From: Simon Davis
Sent: 11 February 2022 12:46
To: 'Nigel Jarvis' [REDACTED]
Subject: RE: AL/129/21/OUT

Subject: AL/129/21/OUT

In reviewing the objections just now, I have noted a comment from the owner of the Paddock stating that the redline boundary cuts 3 meters of their garden. Having compared the red edge to our own GIS maps, it does appear that the site boundary takes off land from the garden (note position of thick red line versus the thinner one):

Fig 02 - Location Plan

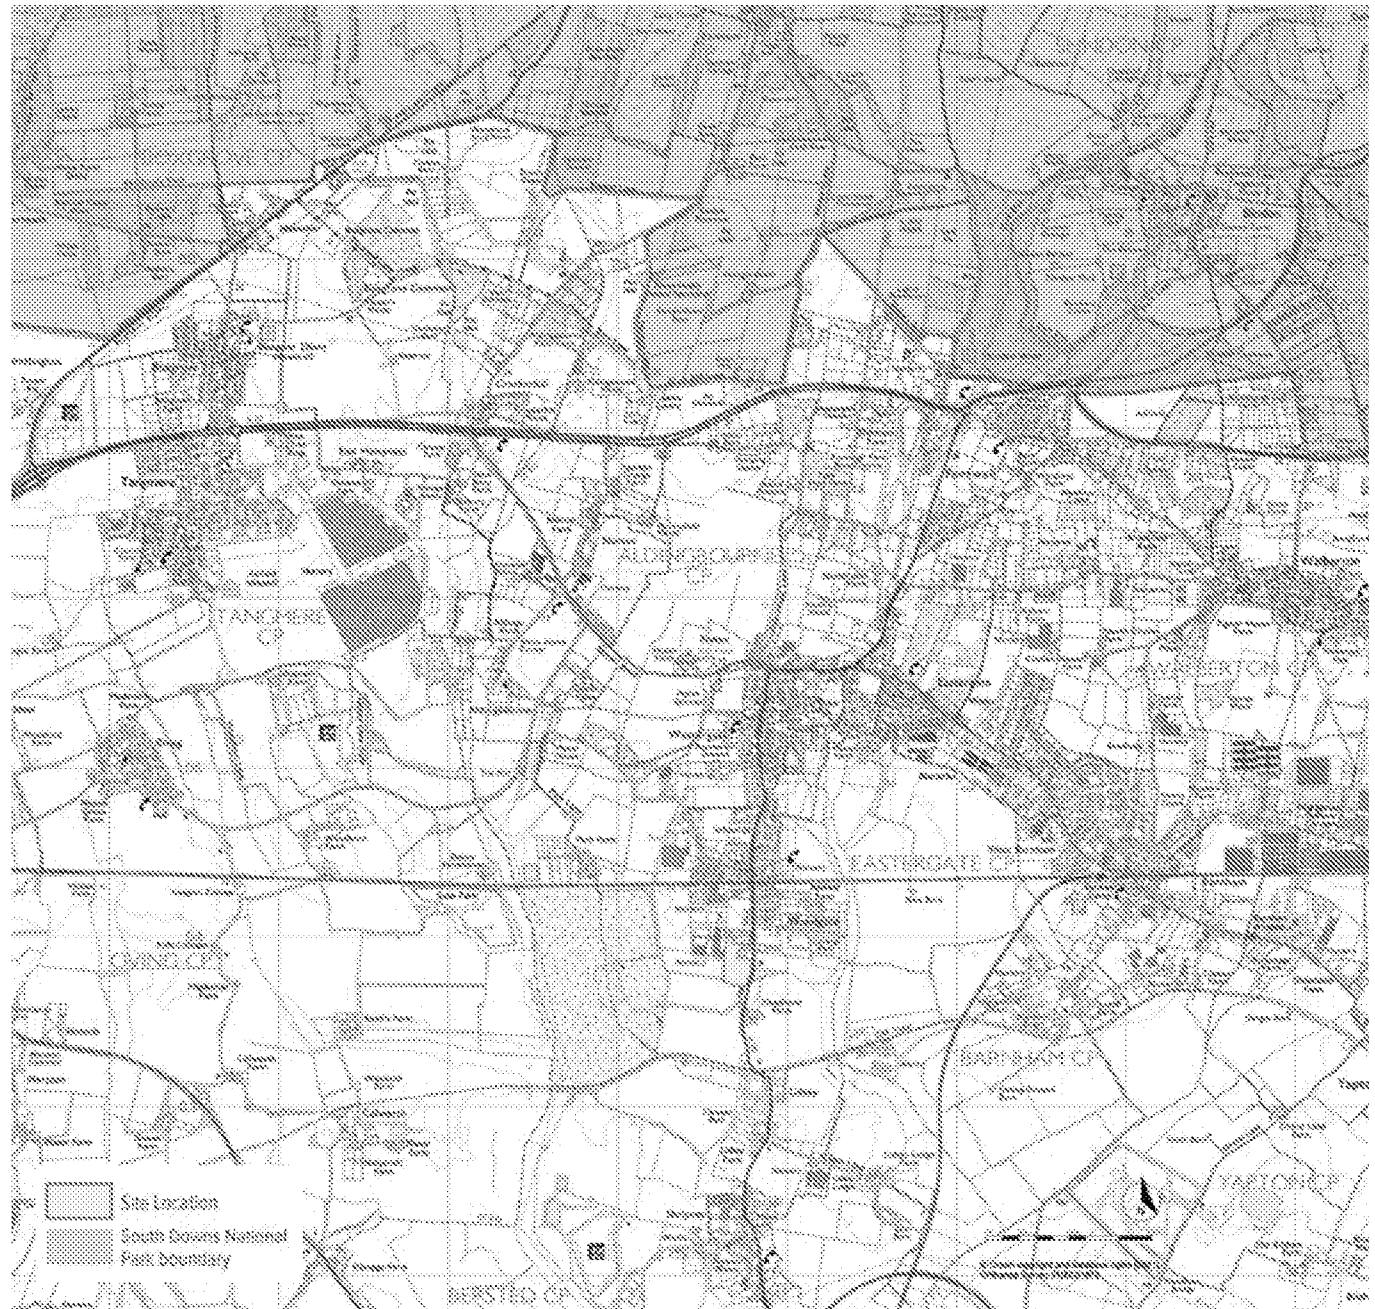
Please can you advise whether the red edge is correct. If so (and assuming that the 3m part of their garden is not owned by the Langmeads) then you will need to serve notice on them.

I'm sure these were checked against the various Title plans but I will quickly confer with my client (copied – James FYI) and we will come back to you asap.
